Green Hill Solar Farm responses to ExQ2 and Comments on
Responses to Written Representations (Deadline 3)

Trading as FC & CC Elderton

Re: Land at Glebe Farm, Great Doddington, Earls Barton and of The Meadows, Earls Barton.

Title:
Figure 13.15: Access Locations for Sites and
Cable Route Corridor (South Area Part 1)

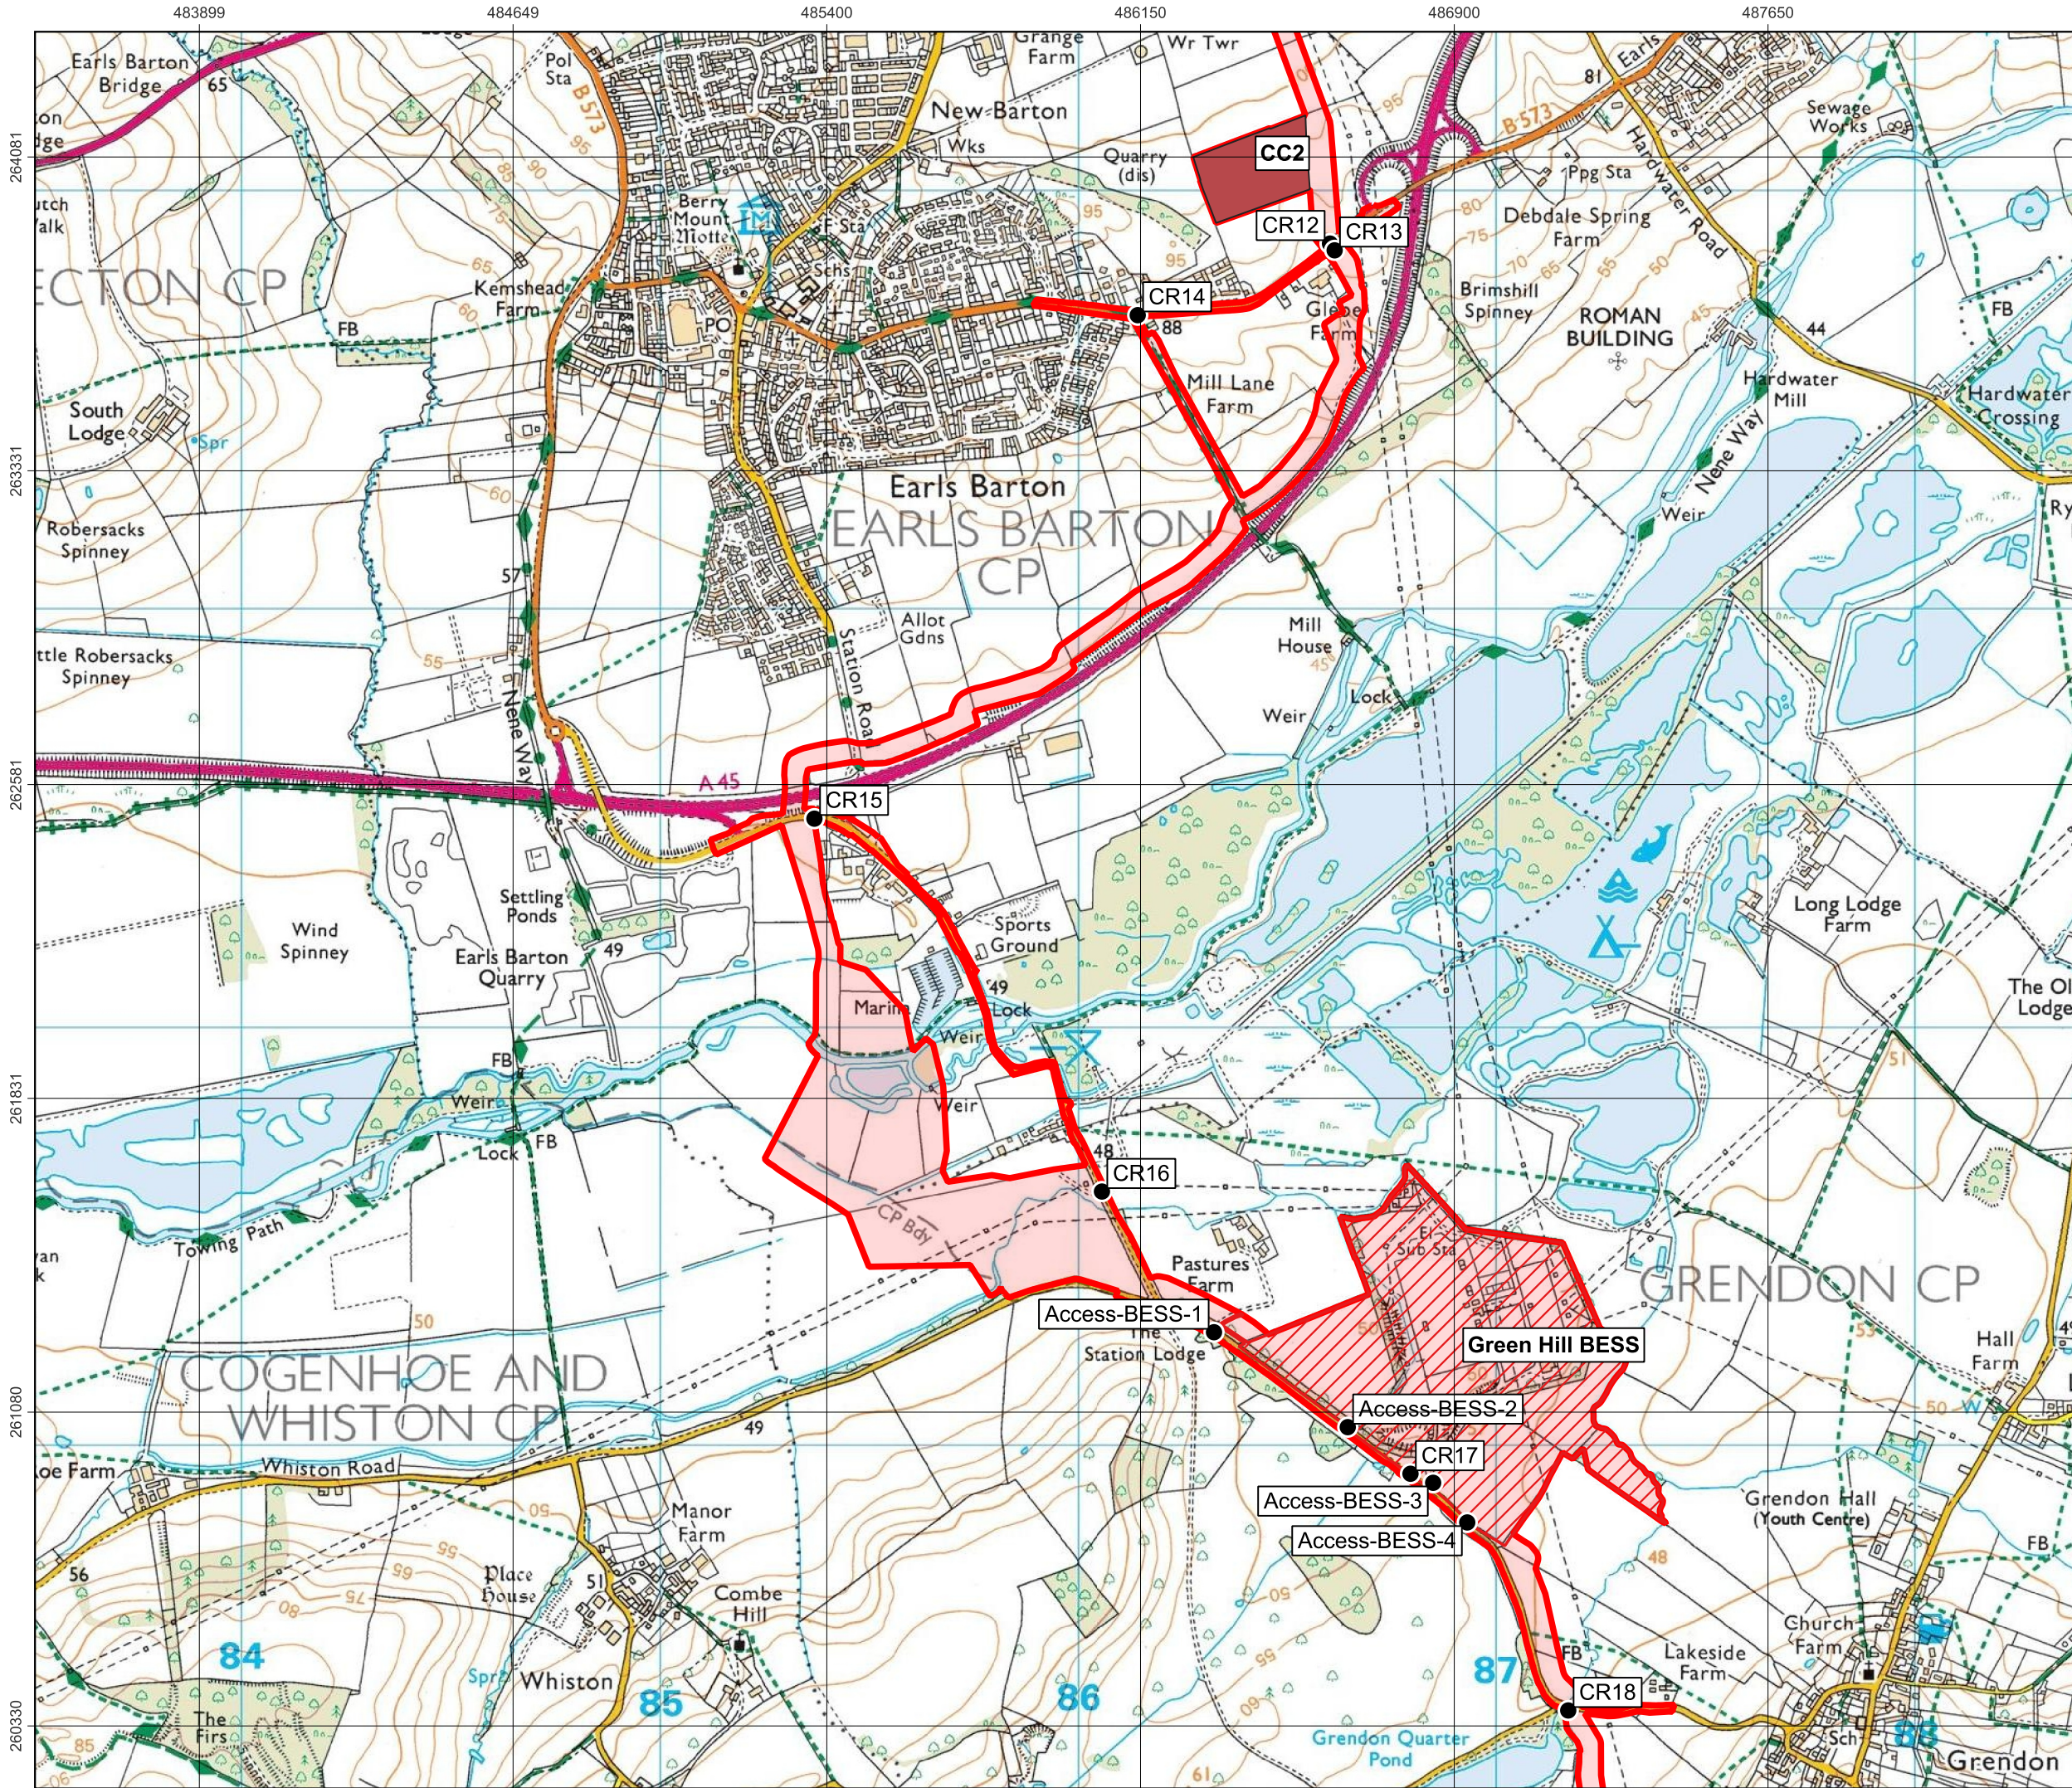
2.1 The Applicant's response (ELD-004) fails to adequately address the concerns raised in our Written Representations (in particular paragraphs 3.1 and 3.7), as it is non-committal and lacks sufficient detail to enable the likely impacts to be properly assessed. Whilst the size of the compound is a consideration, the primary issue is its proposed location within a larger parcel of land. If the compound is located as it is proposed at the furthest point from the public highway, with access provided via a track bisecting land to the west of the cable route, this would materially compromise the ability to carry out normal agricultural operations across at least half of the field.

2.2 Locating the compound to the east of the cable route would allow the land to the west to remain in agricultural use and would significantly reduce operational disruption and consequential losses. If the presence of overhead lines prevents the relocation of the construction compound, we expect our clients to be adequately compensated for any disturbance or injurious affection caused to the retained land. In the absence of a defined and secured compound location, the Examining Authority cannot be satisfied that the proposed design has been minimised so far as reasonably practicable or that impacts on the farm business have been adequately mitigated.

4.2 Construction Compound – Relocate the compound to the easternmost boundaries adjacent to the A45 to allow continued farming on land west of the cable route. The location must be fixed and not subject to post-consent design flexibility.
